Engineers Comments Regarding Surface Water Drainage

Application No:	AL/37/20/DOC
Registered:	4th May 2020
Site Address:	Forge House Nyton Road Westergate PO20 3UP
Grid Reference:	494185 105564
Description of Works:	Approval of details reserved by condition imposed under ref APP/C3810/W1/3213581 (AL/129/17/PL) relating to Condition No 3 - surface water drainage

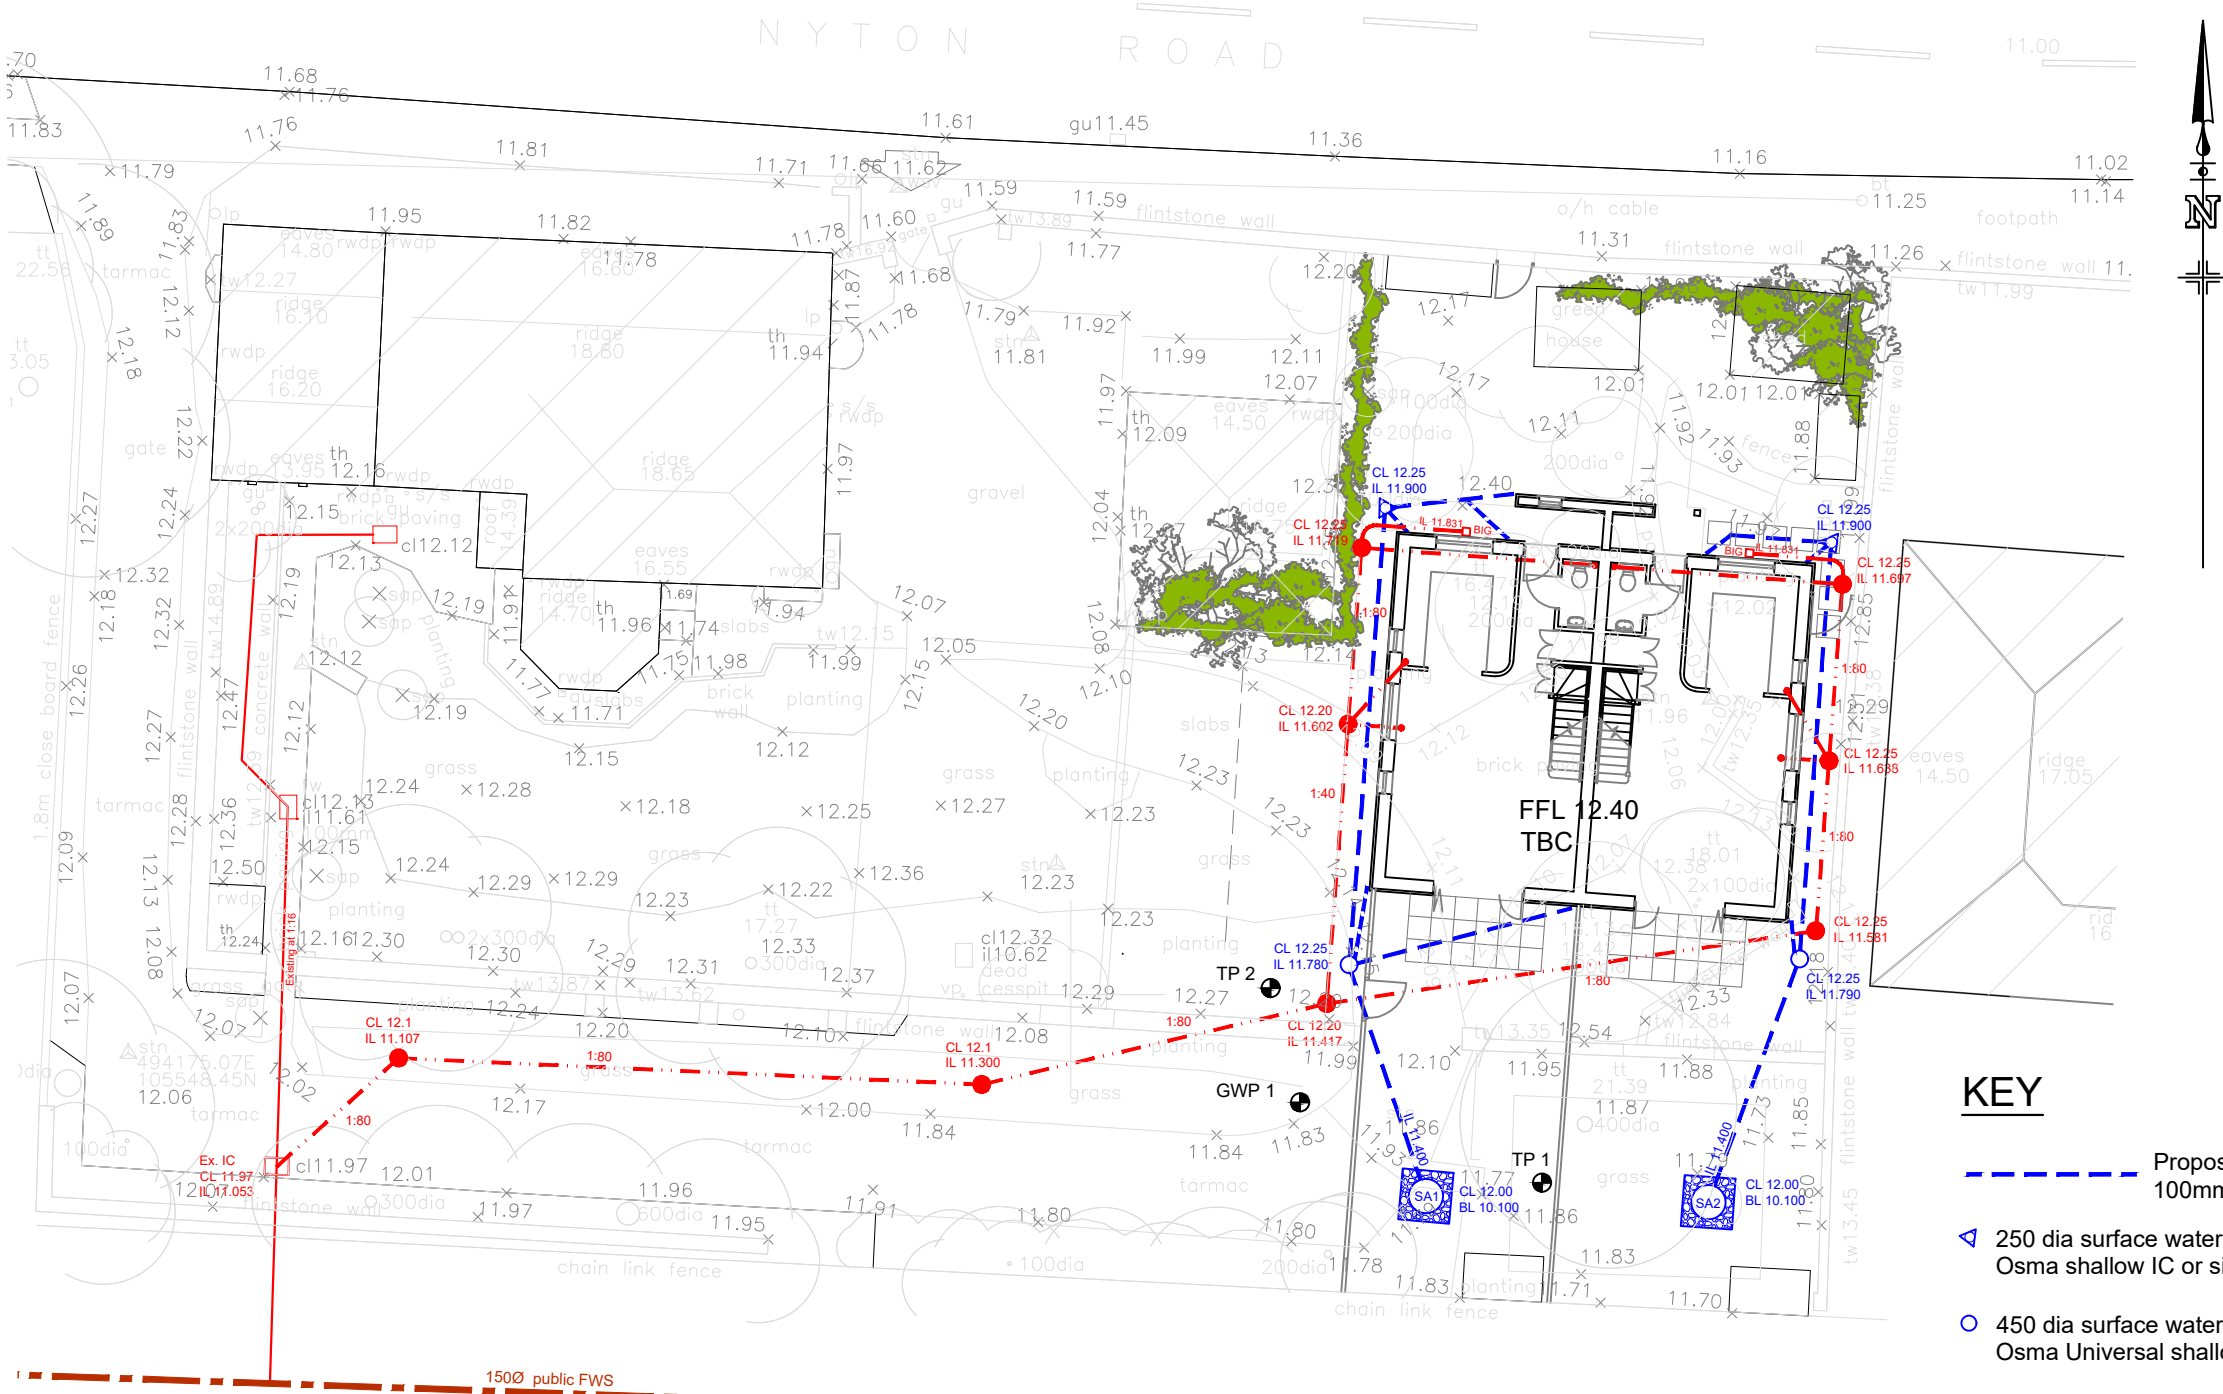
1. Please provide silt traps (or sumps on inspection chambers) upstream of the soakaways. Whilst it is acknowledged that the concrete ring soakaways are accessible for clearance, silt traps are easier to clear.
2. Please provide a construction detail for a concrete pipe bed and surround for where pipe depths are less than 900mm. Plus amend note as to when each surround should be used (Granular where cover to crown is greater than 1200mm in vehicular areas, or greater than 900mm elsewhere. For shallower depths concrete surround.)
3. Please provide a construction detail for the inspection chambers, and silt traps (see point 1).
4. Please confirm the dimensions of the trial pits within the Surface Water Drainage Notes.
